Upper Lachlan Shire Council

Our Ref: F11/244 and CE2015/2885

Your Ref: MP 10_0156 MOD 1

RE: COLLECTOR WIND FARM MODIFICATION 1 - (MP 10_0156 MOD 1)

MODIFIED PROJECT LAYOUT

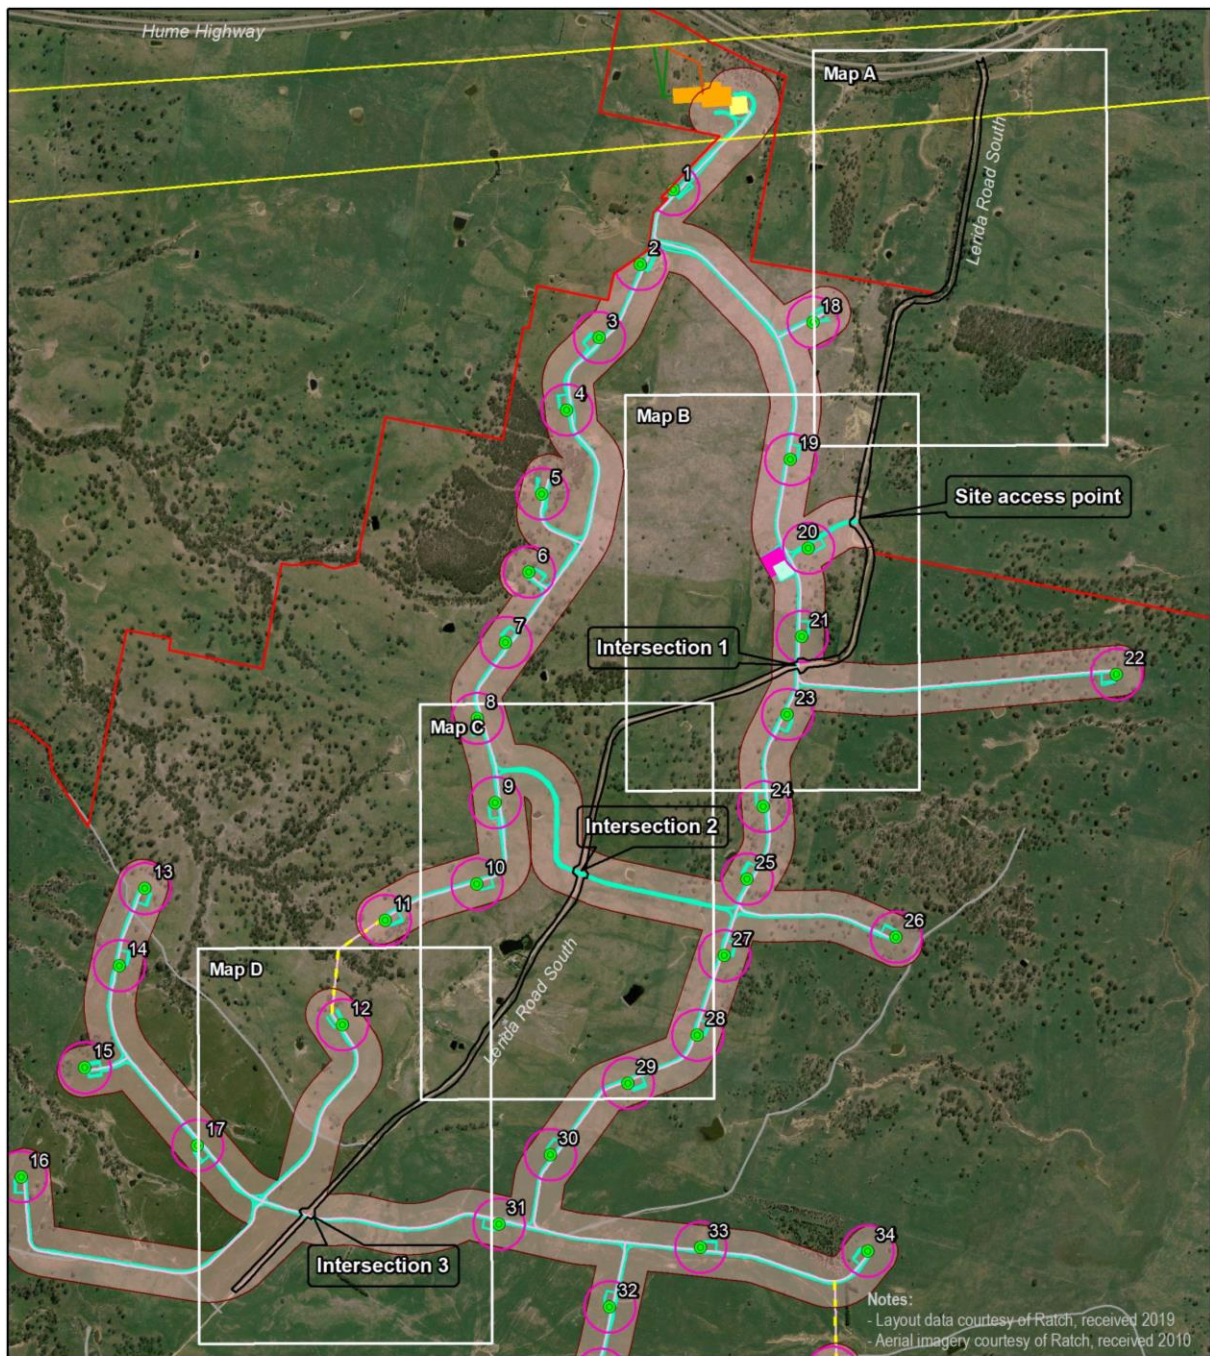
1. The proposed road modifications do not reduce the usage of Lerida Road South – they increase it significantly.

Should the proponent wish to use additional lengths of Lerida Road South, the road must be reconstructed and sealed to a location that is a minimum of 250m south of the southernmost intersection i.e. 250m south of the intersection near WTG's 17 and 31.

The statement that 'ULSC has a clear preference to minimise the use of Lerida Road South' means that ULSC requires all traffic associated with the wind farm to exit off Lerida Road South at the earliest opportunity and use internal access tracks to access all parts of the development (not Lerida Road South).

2. The addition of further cross intersections raises significant concerns regarding road safety. ULSC agrees with the commonly held view that cross intersections encourage unsafe acts by road users that are crossing Lerida Road South on the access tracks. This behaviour is exacerbated when the intersections carry intermitted and variable traffic which creates complacency within the minds of road users. The fact that children could be involved from time to time increases ULSC's concern regarding road safety. The proposed system would also cause problems for farmers moving stock.

Considering all of the above comments, ULSC considers that it will be much safer to construct staggered "T" intersection to replace the crosses. It will not be difficult to design and construct "T" intersections that can be traversed by Over Mass and Over Dimension vehicles easily. These intersections will require line marking to channelise small vehicle movements. The actual entry points for each access also must be located a considerable distance away from the road (minimum 75m setback) to allow for vehicles to be clear of the road whilst opening the gate (or crossing the grid).

3. The intersection of the proposed new road between WTG's 12/16 and WTG's 17/31 is located too close to Lerida Road South – it should be approximately 250m from Lerida Road South.
4. ULSC would like to reiterate that RATCH-Australia Corporation, to date, has made no commitment to Council that Council will be the entity responsible for the management of the Community Enhancement Fund expressly stated in Condition C2 of the Project Approval.
